LSC Responses to Comments – Meadowlake Industrial Park 7/29/2022

PCD Engineering Comments:

Figure 2  
**Site Plan**

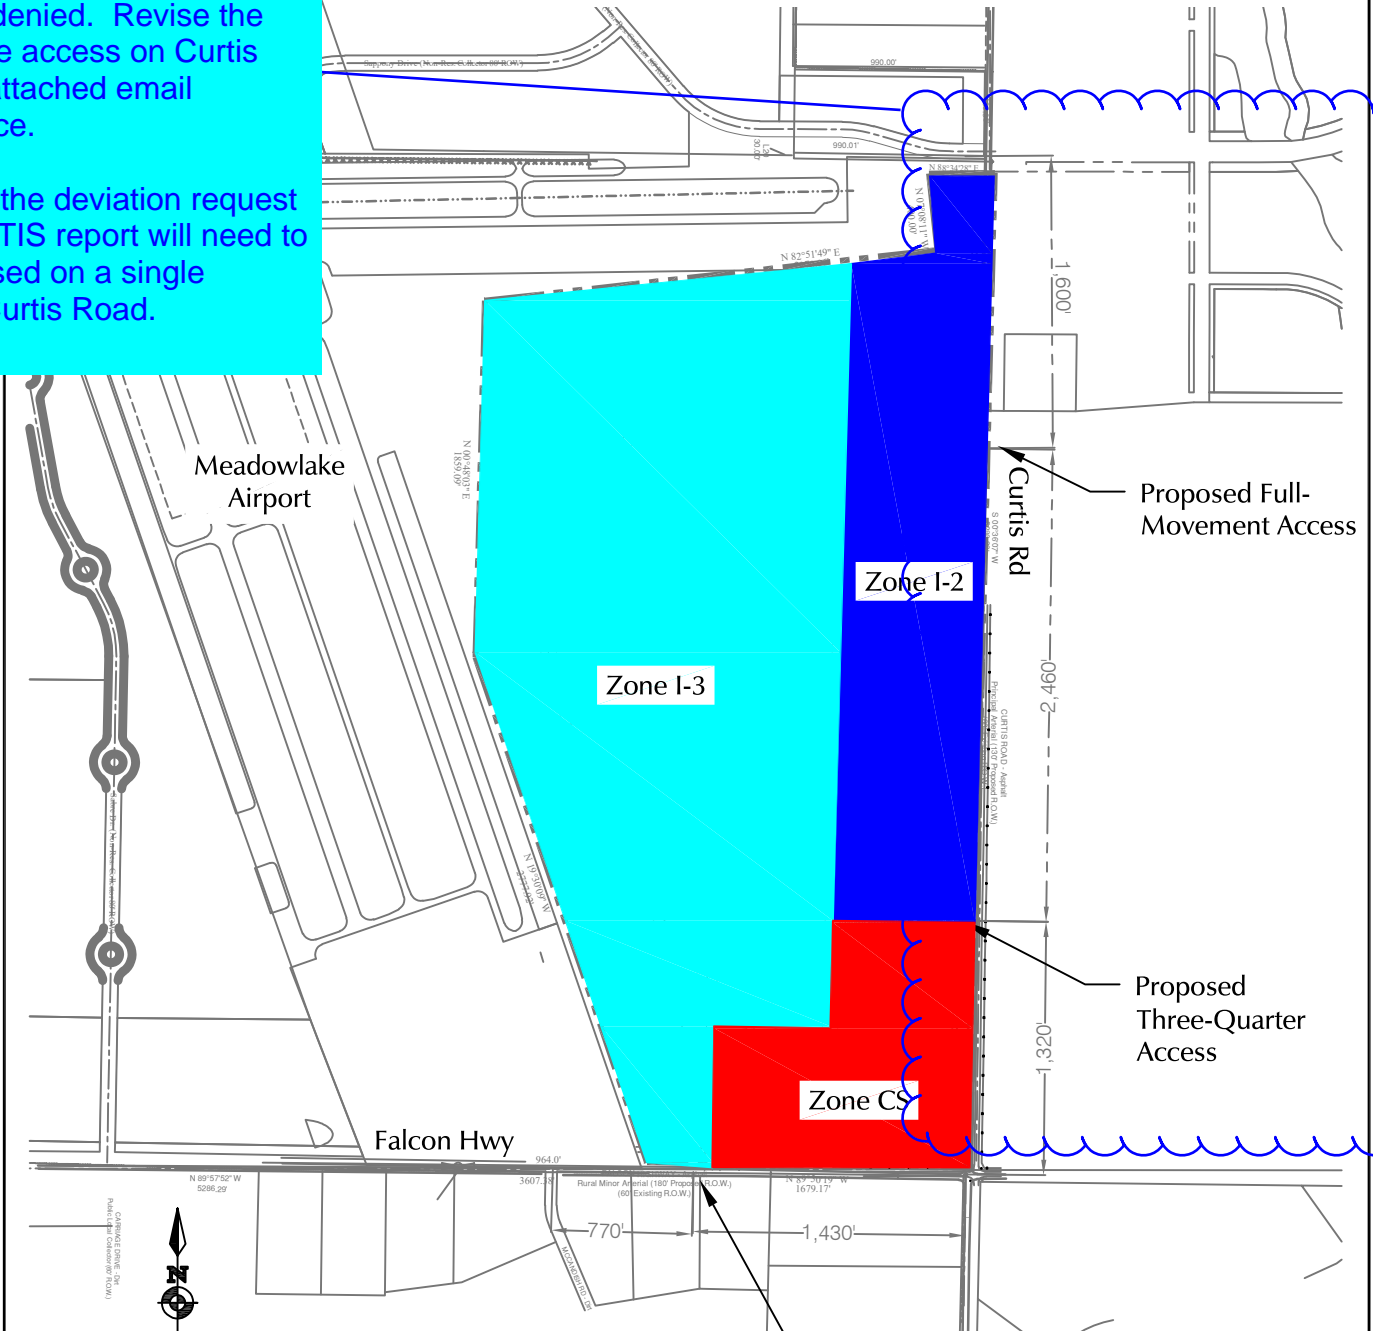
Review #2: 1. Update the deviation request as discussed with the Engineering Review Manager: - Proposed full movement intersection 1/2 mile north of Curtis/Falcon intersection. - Right-In/Right-Out between the full movement and Curtis/Falcon intersection. Approximately 1,295' north of Curtis/Falcon intersection - Revise the Falcon Hwy proposed access to full movement intersection.

LSC Response: The deviation for the Curtis Road access has been revised as requested. The access to Falcon Highway needs to remain a 3/4 movement intersection due to substandard intersection sight distance to the west (for trucks). The TIS continues to show the 3/4 movement configuration. The deviation for the Curtis Road access has been revised to include discussion of the sight distance limitation at the Falcon Highway access.
